**WELWYN HATFIELD BOROUGH COUNCIL
EXECUTIVE DIRECTOR - PLANNING, PUBLIC PROTECTION AND GOVERNANCE**

DELEGATED APPLICATION

Application No: 6/2021/1184/PN15
Location: The Galleria Telecommunications Site 61149/WEH010 Comet Way Hatfield AL10 0XR
Proposal: Removal and replacement of 6no antennas. Internal upgrade of existing equipment room and associated ancillary works
Officer: Ms Kirsty Shirley
Recommendation: Prior Approval Refused

Title: **215 MAX CONFIGURATION SITE PLAN**

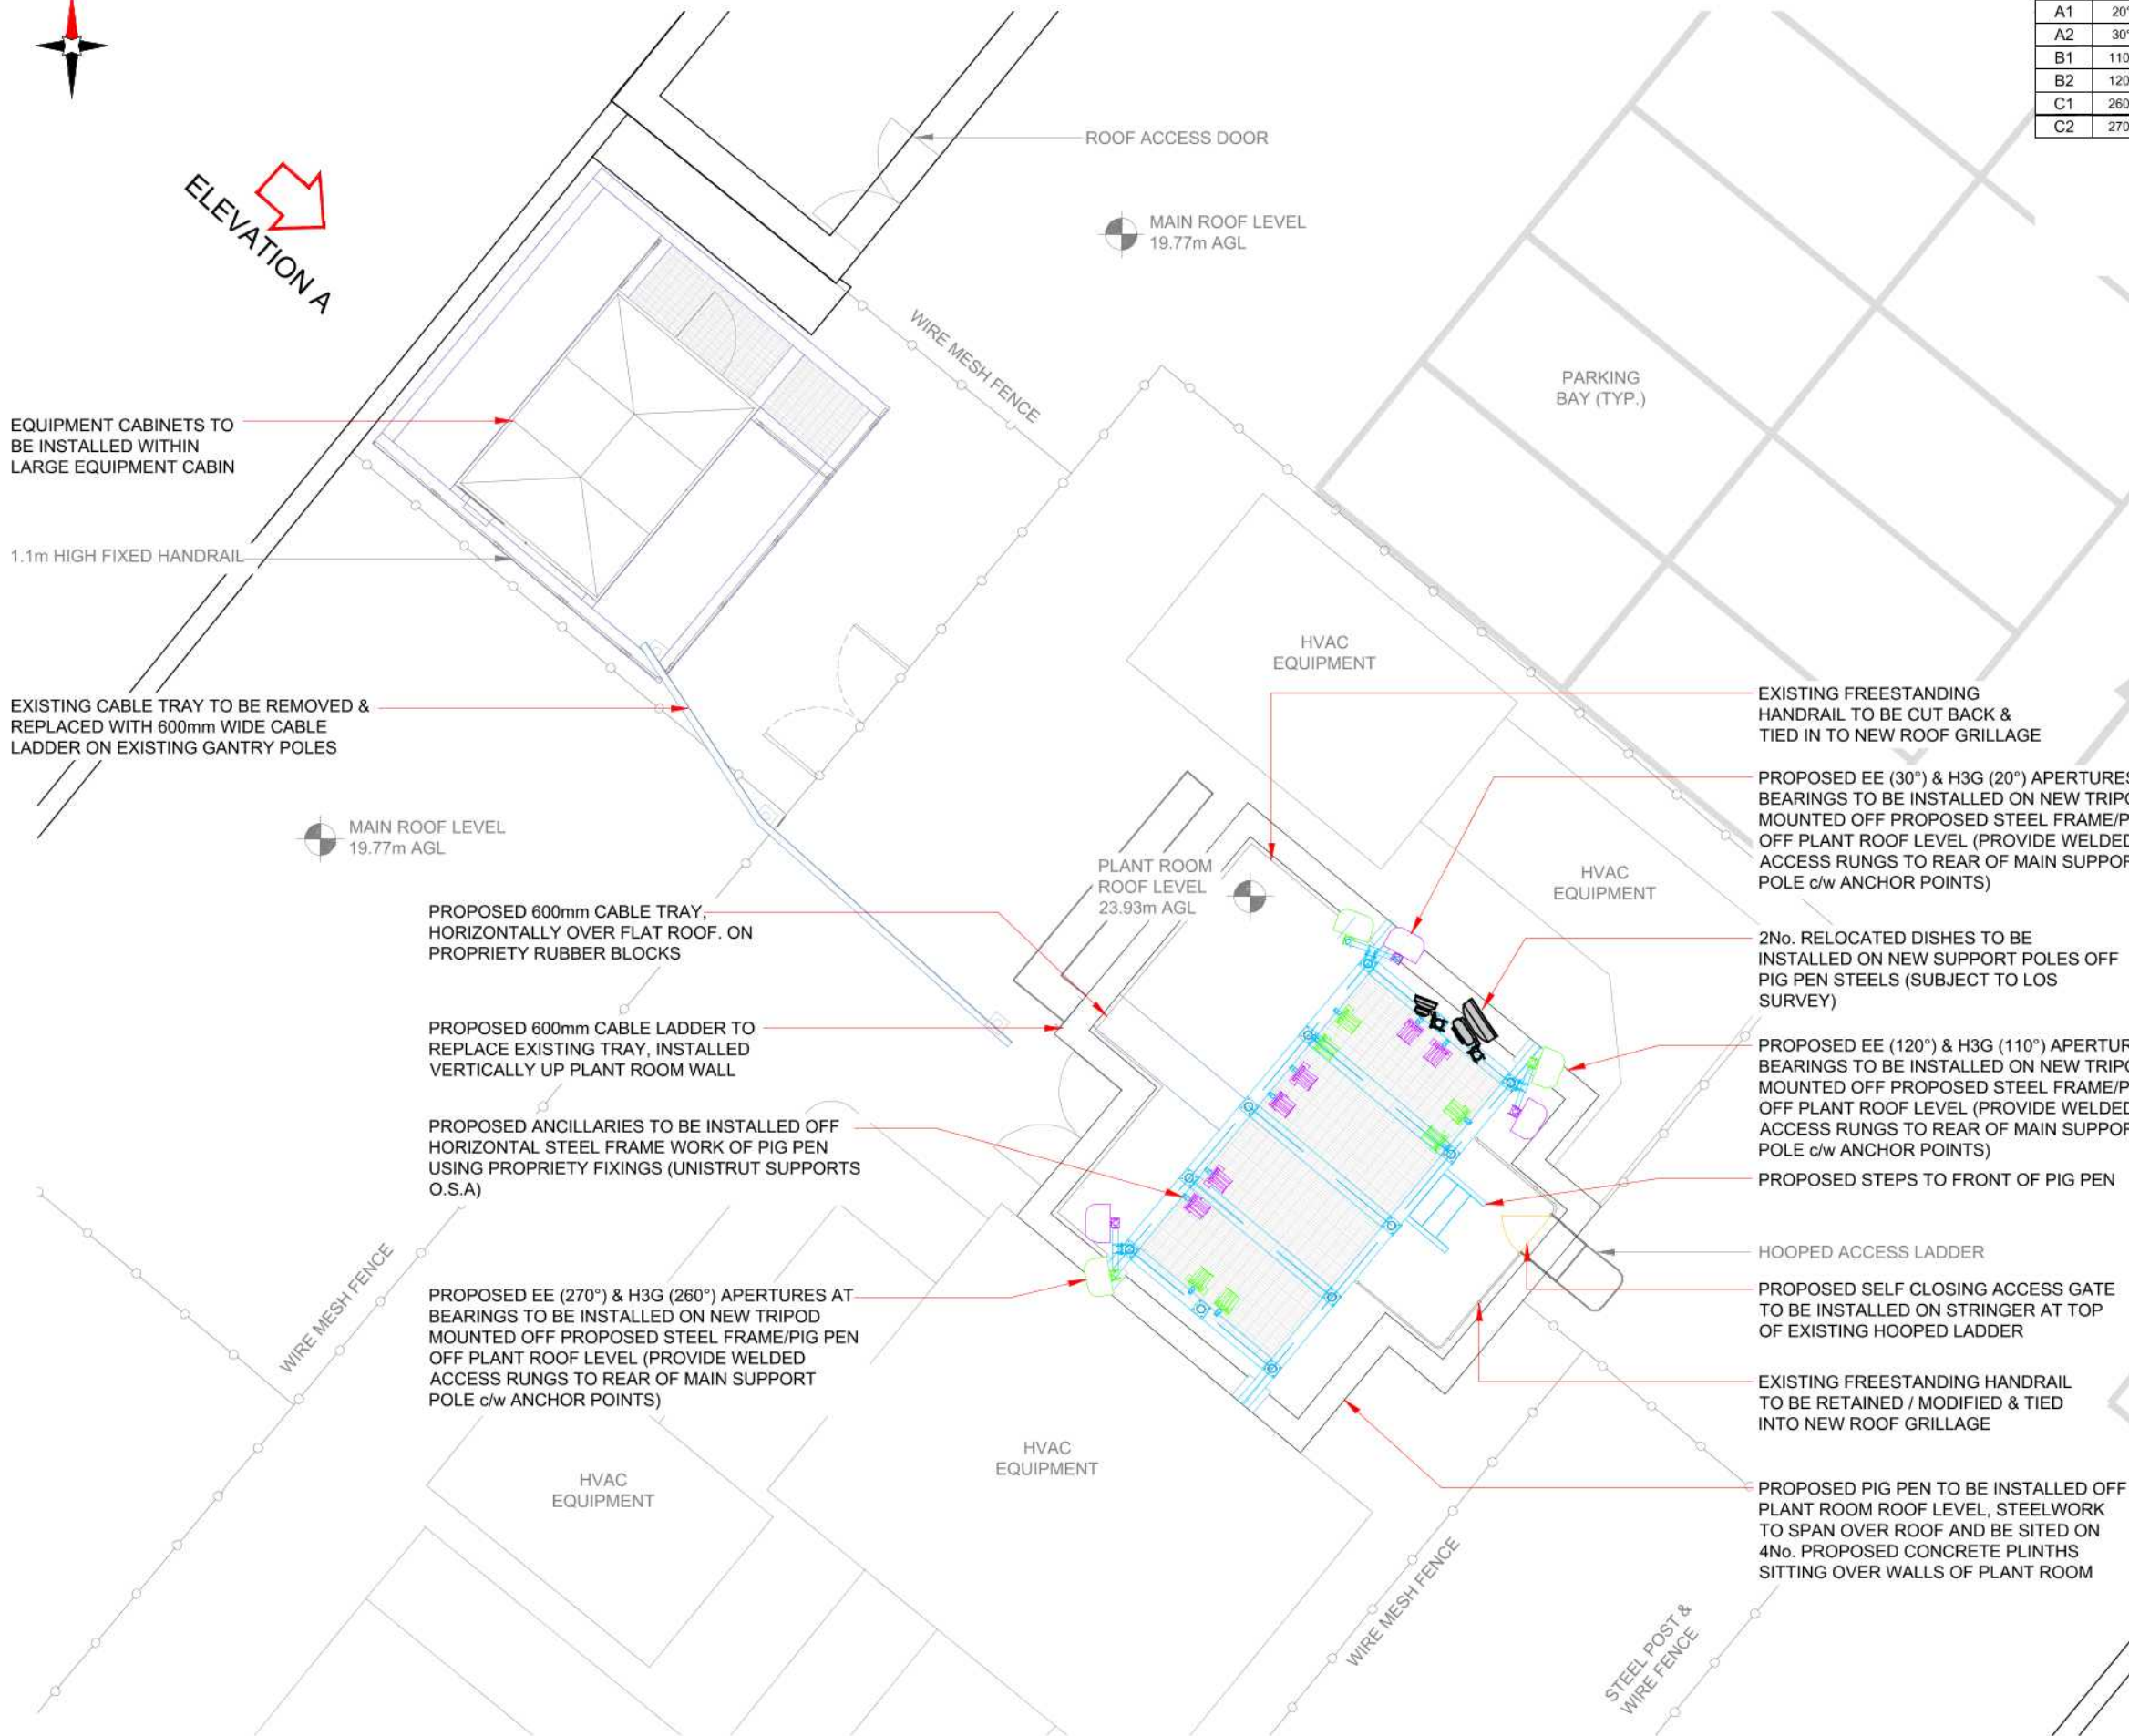
- The proposal is for 6 replacement antennas with associated ancillary works located on a building.

The proposed development would be comparable in terms of location and function to the equipment that already exists on the building, and the size and scale of the proposal does not harm the appearance of the building.

Title: **265 MAX CONFIGURATION ELEVATION**

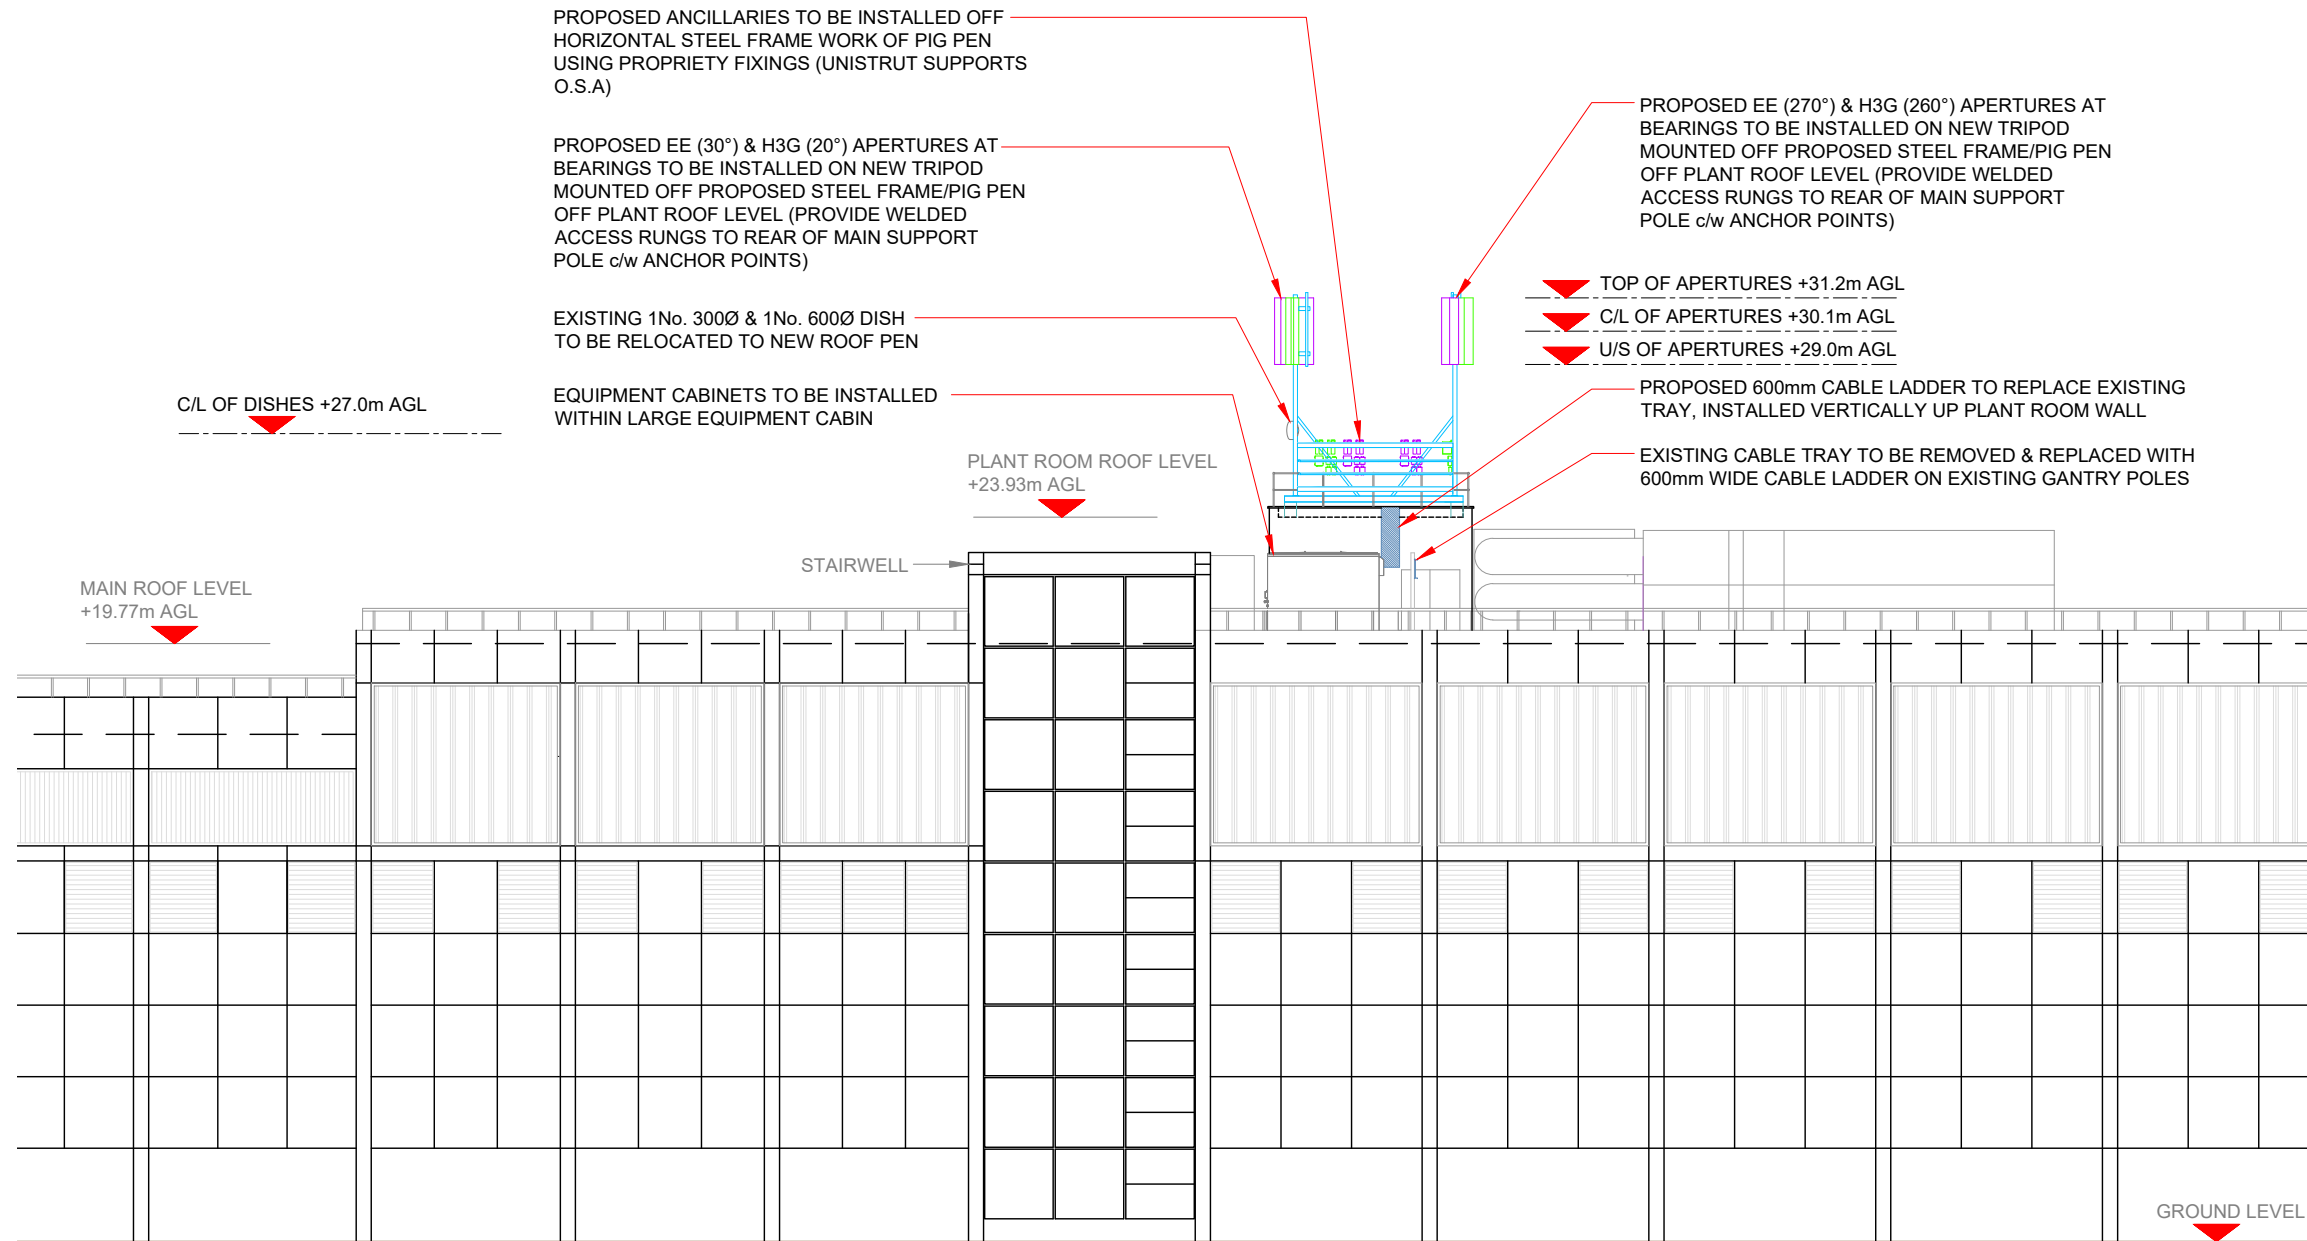
- In this case, the building is 15 metres or more in height, and the development would result in the presence on that building of more than 2 such antennas

It is considered that the proposed equipment would be not compliant with Schedule 2, Part 16 Class A of The Town and Country Planning (General Permitted Development) (England) (Amendment) (No.2) Order 2016 by virtue of failing to comply with condition A.1 (6) (a).

1. It is considered that the proposed equipment would be not compliant with Schedule 2, Part 16 Class A of The Town and Country Planning (General Permitted Development) (England) (Amendment) (No.2) Order 2016 by virtue of failing to comply with condition A.1 (6) (a).
